## **Application by Highways England for M54 to M6 Link Road**

### **The Examining Authority's further written questions and requests for information (ExQ2)**

**Issued on 4 December 2020**

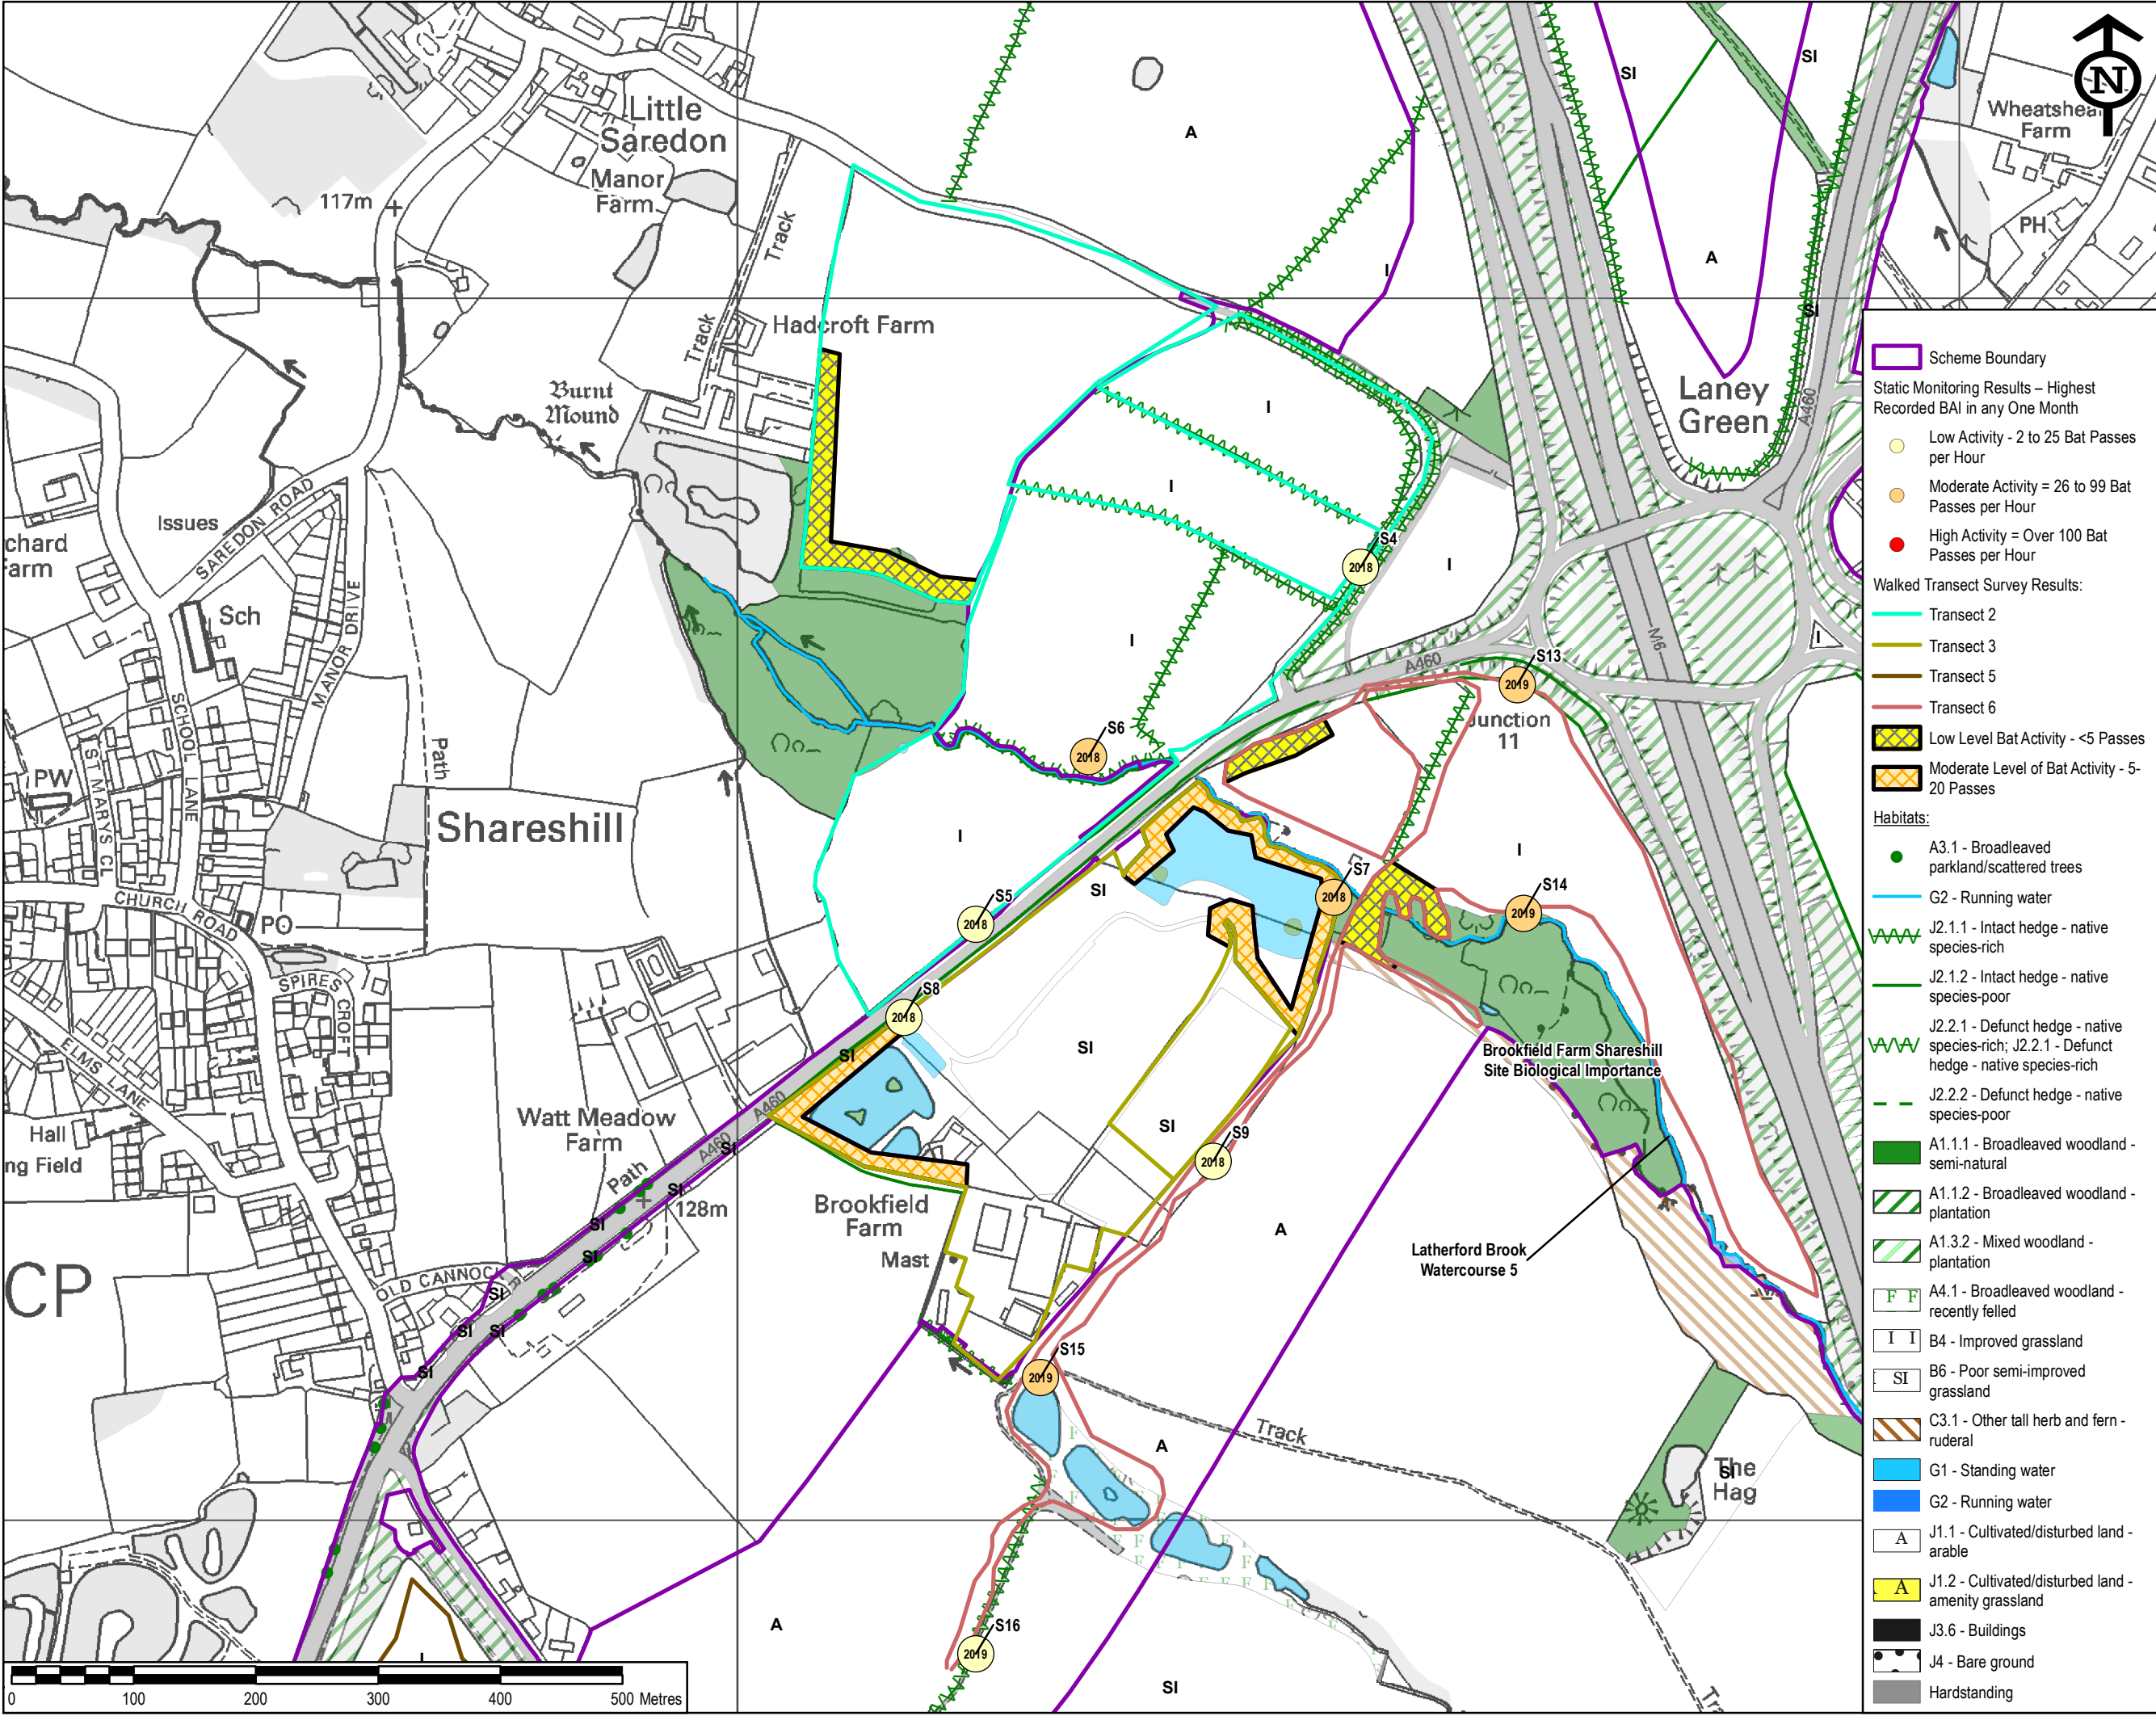
2.3.5	The Applicant	<p><b>ES Figure 8.18</b></p> <p>The Guide to the Application [REP3-002/REP3-003] indicates that Environmental Statement Figure 8.18: Bat Baseline - Transect Activity Survey Results (2018 and 2019) [APP-122] has six sheets. However, the submitted document only has three sheets. Could this be clarified?</p>
